## Application for a Non-Material Amendment Following a Grant of Planning Permission

demolition of the existing dwelling and erection of a two storey plus lower ground floor level detached dwellinghouse with integral garage, associated refuse/recycling store, cycle store, amenity space and provision of 2no.off street parking spaces

22/0501/ful

Proposal
As Built Elevations

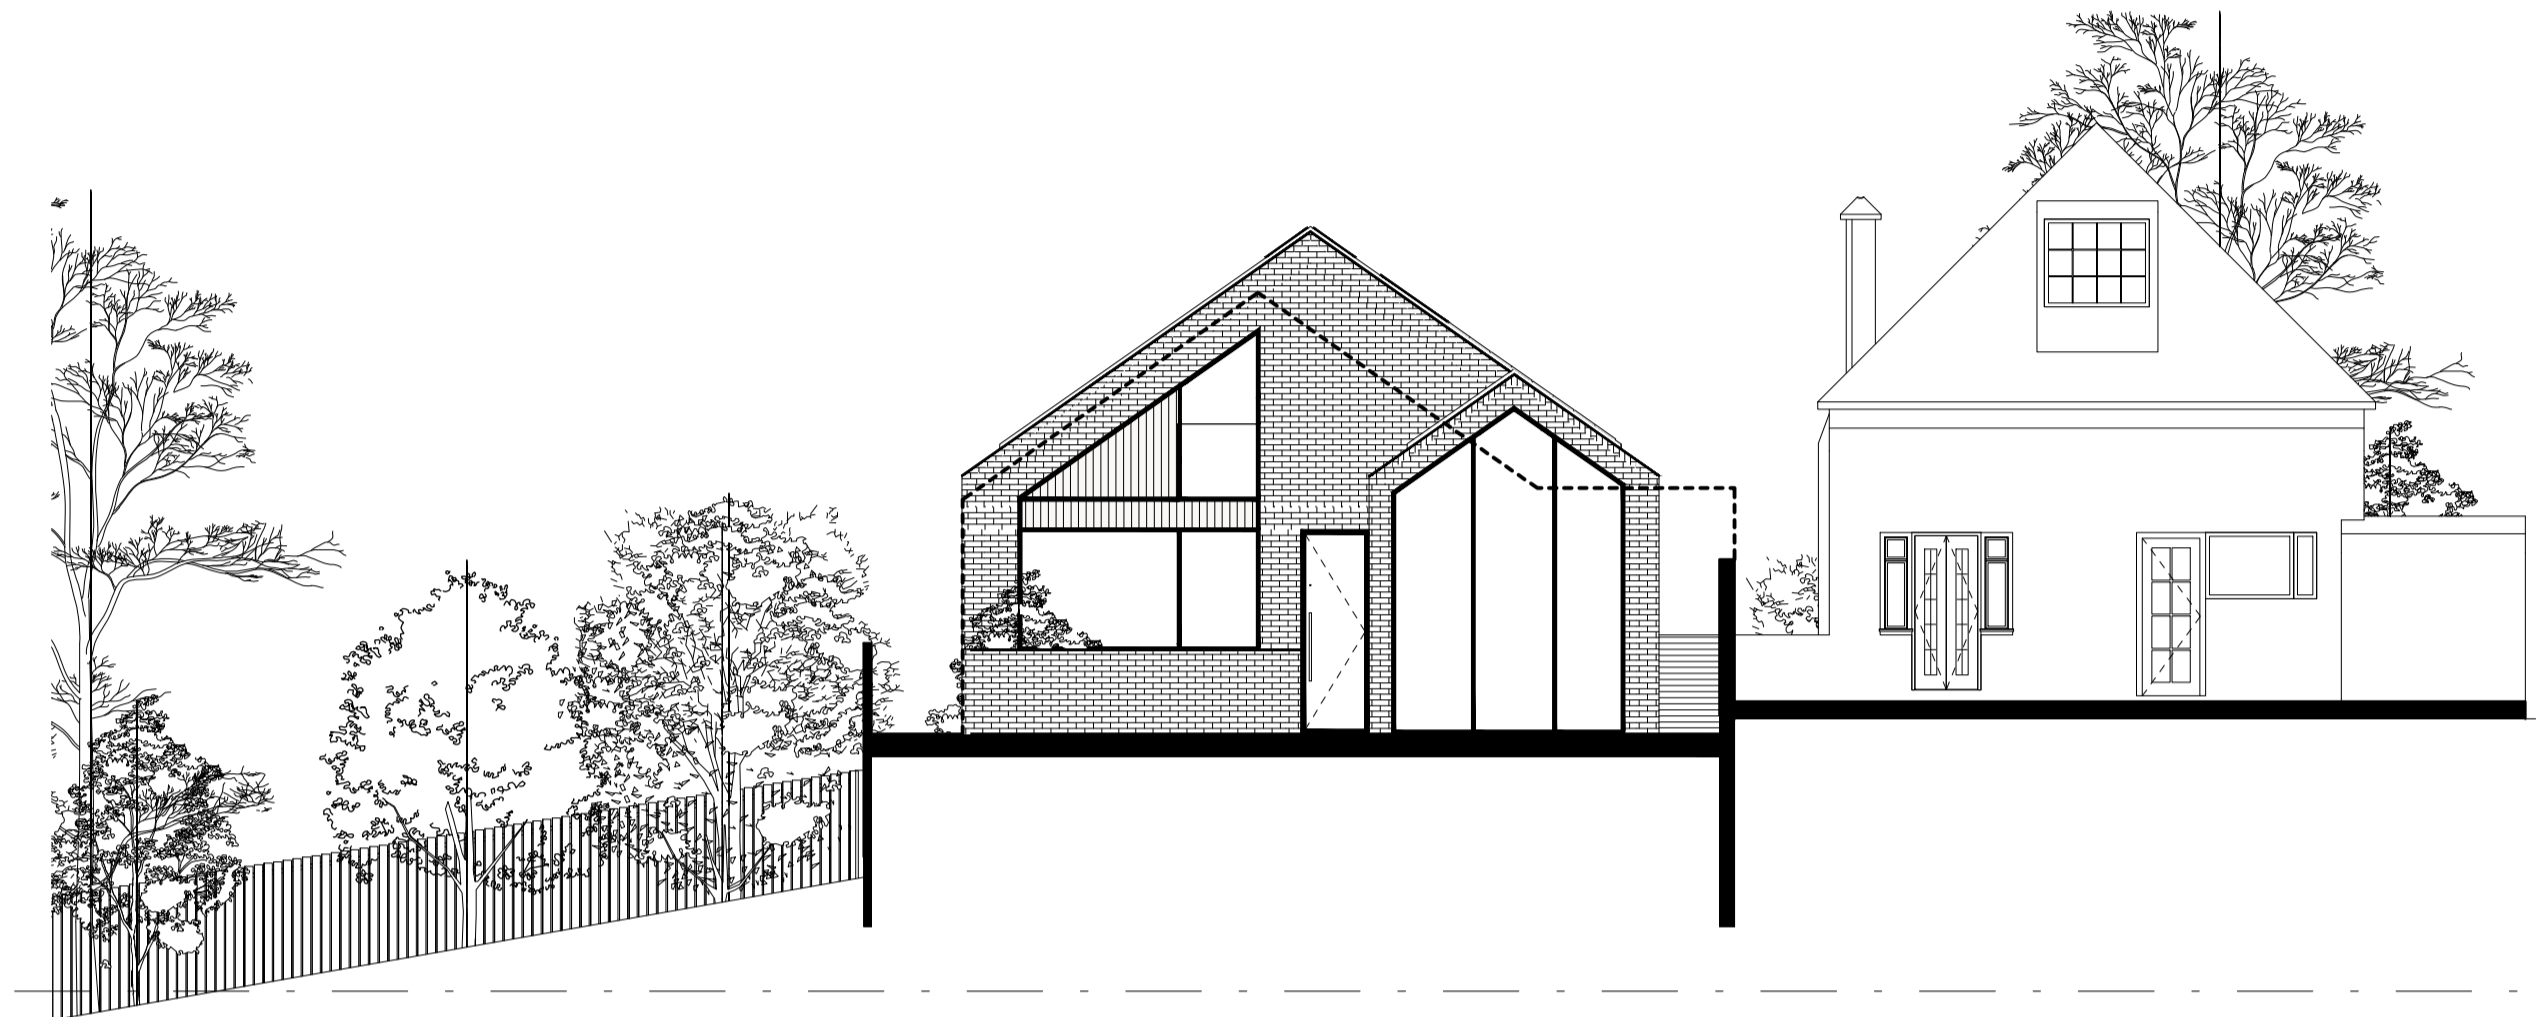
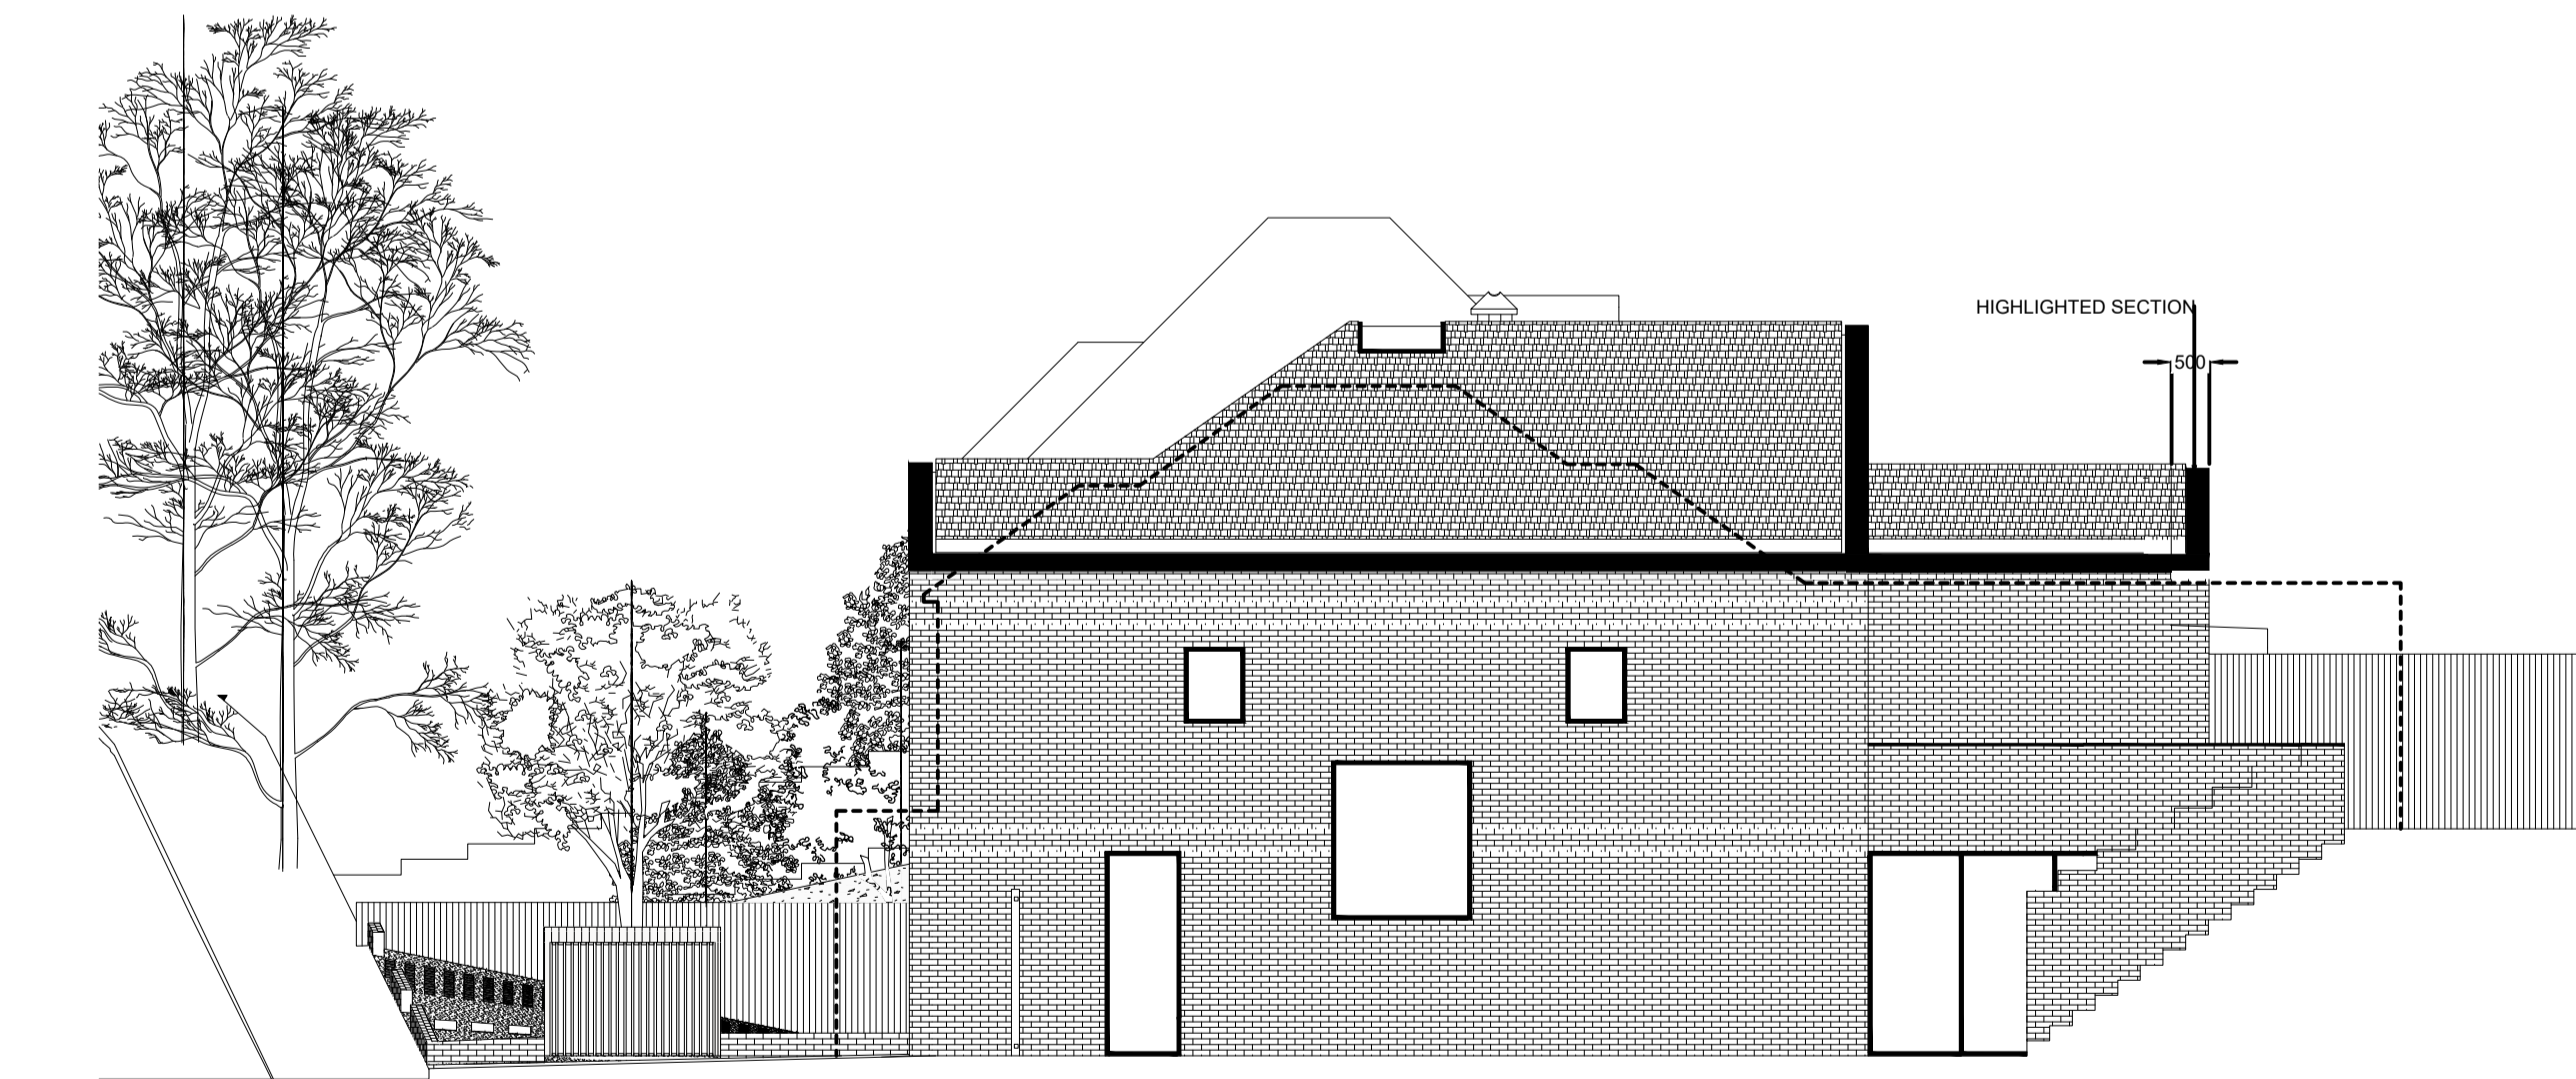
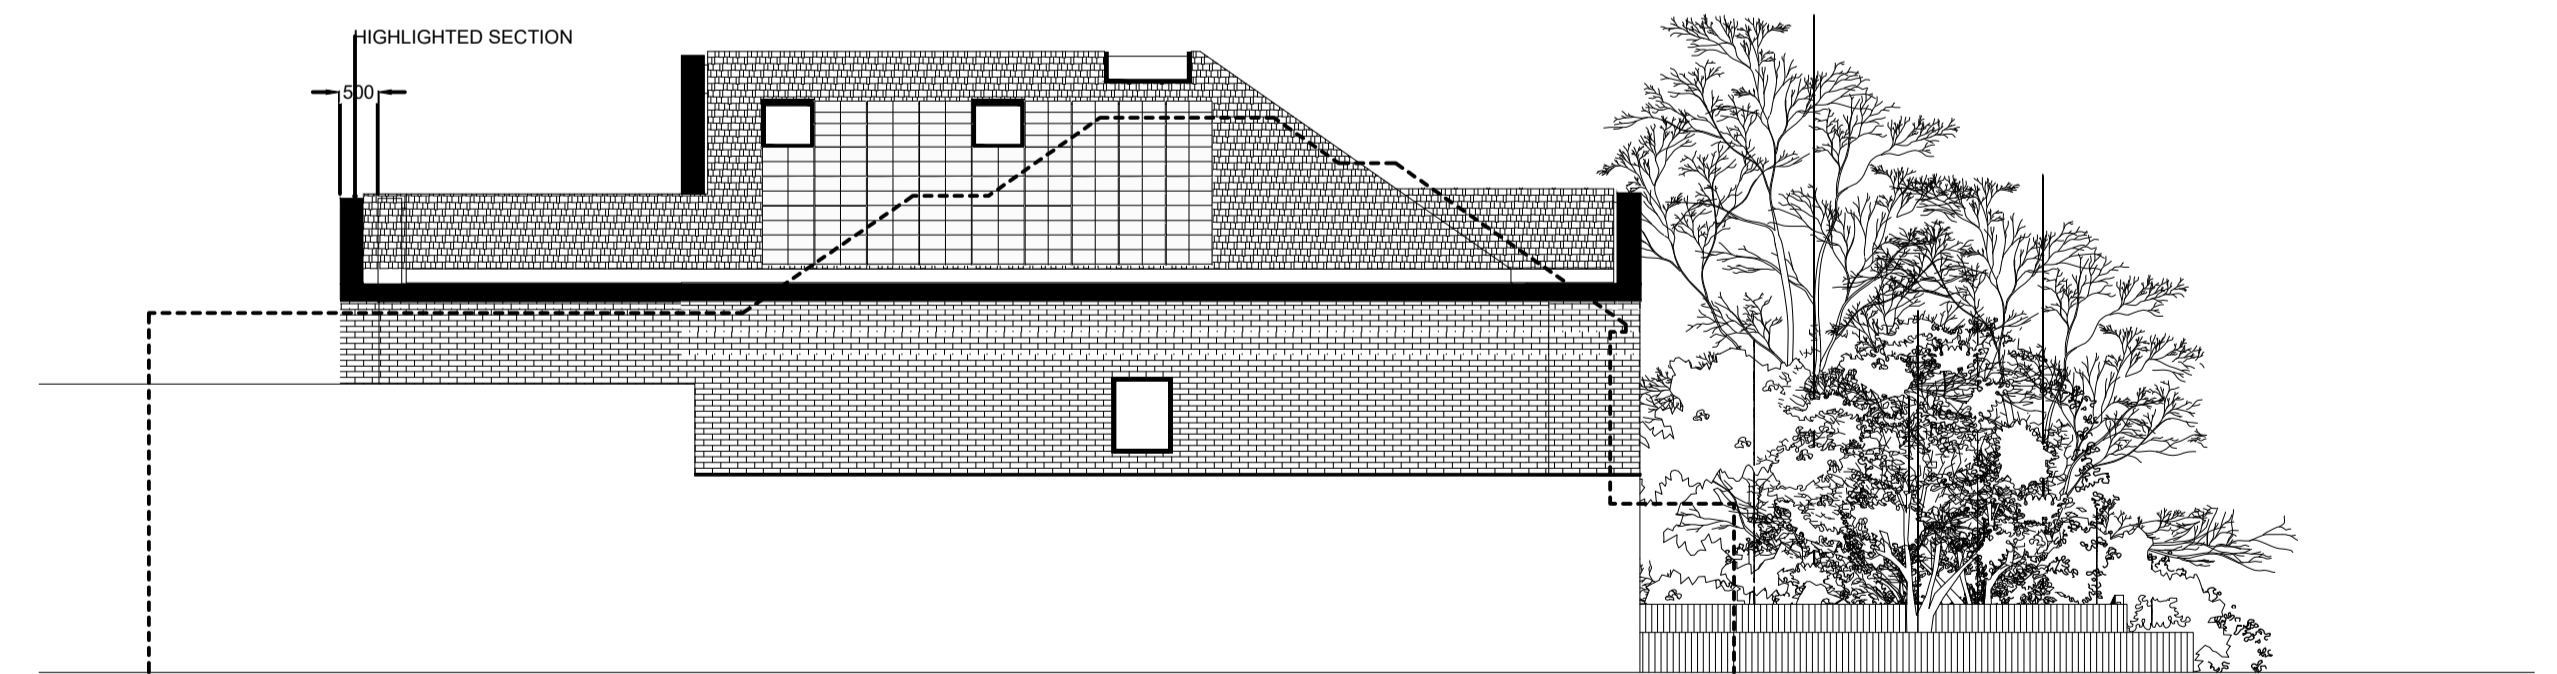
the back addition part of the build has been extended by 500mm

to rectify the build
